Recommendation Report for Planning Permission for Works or Extension to a Dwelling

REF NO: LU/314/24/HH

LOCATION: 15 Highdown Drive  
Littlehampton  
BN17 6HJ

PROPOSAL: Loft conversion including front and rear dormers

**Drawing:**  
 Plans and elevations as proposed

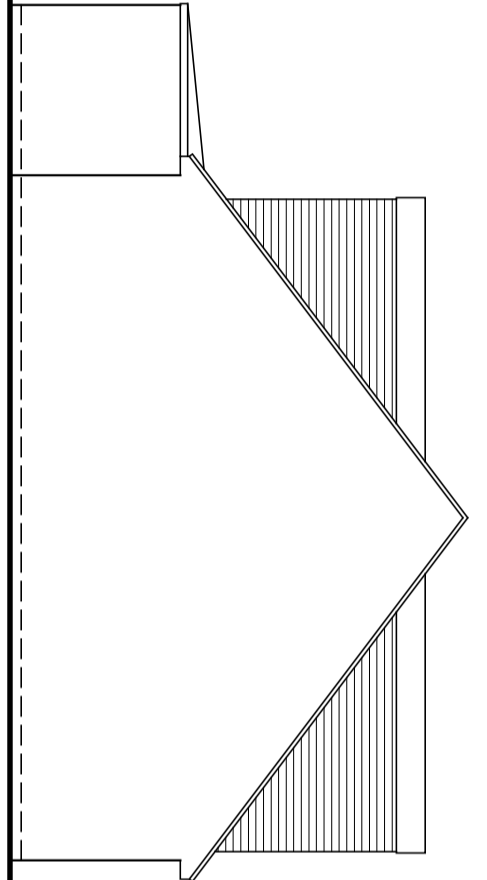
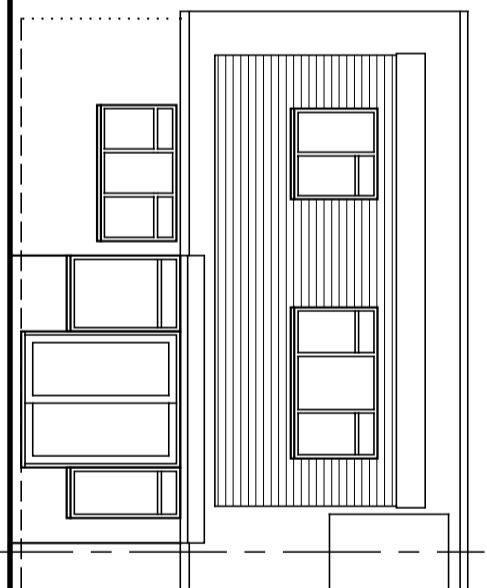
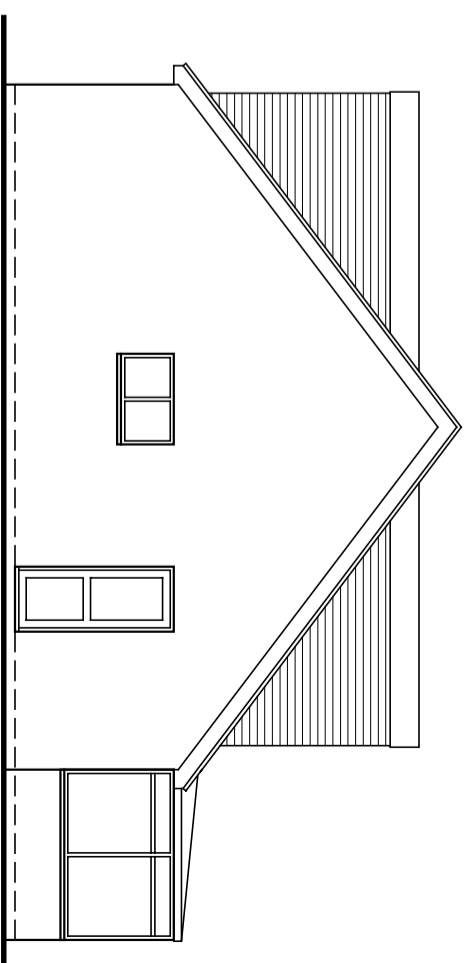
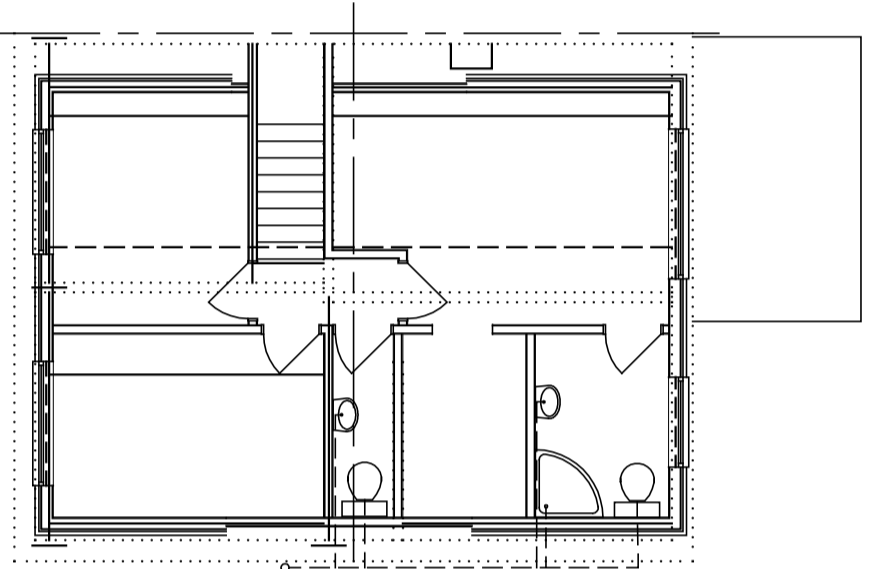
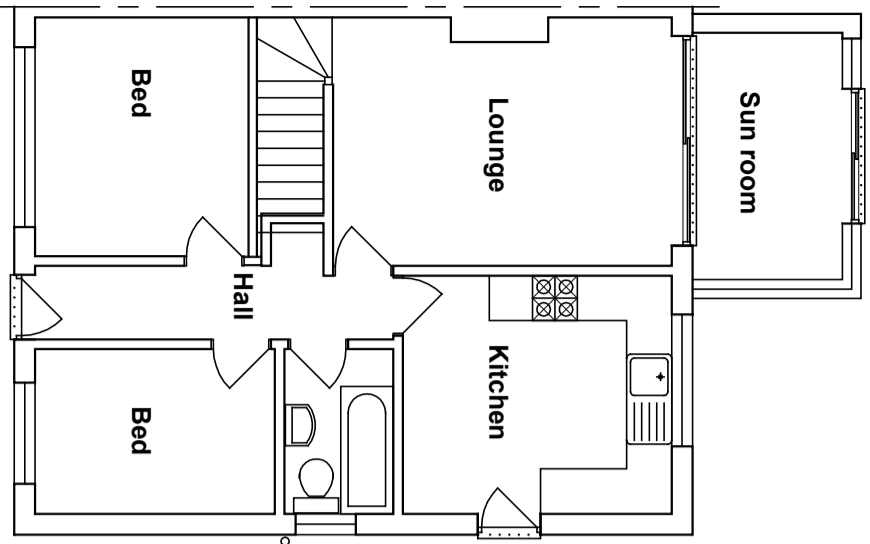
The site is a semi-detached bungalow along Highdown Drive. The application seeks permission for a loft conversion with a front and rear dormer. The proposed development would result in an increase in the bulk of the roof of the dwelling. The proposed front dormer would be visible from the street scene, and some views of the rear dormer would be available from the public realm.

The proposed dormers would be set down from the maximum ridge line of the host dwelling and they would be set in from the flank elevations and set up from the eaves level. A similar loft conversion with front and rear dormers has been constructed at 35 Highdown Drive with other examples of large side and rear dormers also visible from the public realm. As such, the proposed dormers would not harm the character of the area. The dormers would be finished in Cedral board cladding. Whilst the proposed materials would be different to existing, it is noted that there is existing variation within the street scene in terms of extensions and external materials, and as such, the proposed materials would be acceptable.

Part M of ADG requires front dormers to be centrally located and to not damage the original character and appearance of the building and its surrounding area. Whilst the front dormer would alter the original character of the property and front dormers are not a very common feature in the street scene, the main roof ridge height is retained, and the development does not project beyond the original footprint of the property which minimises any visual harm on the locality. Furthermore, there are examples of other front dormers within the street scene. Therefore, the visual impact of the front dormer would be acceptable.

The rear dormer would measure approx. 3.3m in depth, 6m in width and 2.6m in height and would not be readily visible from the street scene, although some views from the public realm may be possible. Two sets of windows are proposed within the rear dormer. The material used for the walls of the dormer would be Cedral board cladding. It is noted that the rear dormer is of a size and scale similar to that which could be constructed under permitted development, and, whilst the materials would not match the host dwelling, as identified above, the street scene is varied in terms of extensions, alterations and external materials. Therefore, the proposed rear dormer is acceptable.

The proposed front and rear dormer windows would be contained within the existing front and rear roofslopes of the host dwelling, and would not result in overshadowing or overbearing impacts to neighbouring properties.

The 2 sets of windows proposed within the front dormer would look onto Highdown Drive and front garden amenity and would not result in any overlooking to neighbouring properties.

The 2 sets of windows proposed within the rear dormer would look onto rear garden amenity and would be set back from the rear boundary fence by approx. 17m. Whilst some views of neighbouring gardens would be available, these views would not be dissimilar to those which could be achieved via constructing a rear dormer under permitted development. As such, the rear dormer would not result in unacceptable overlooking.
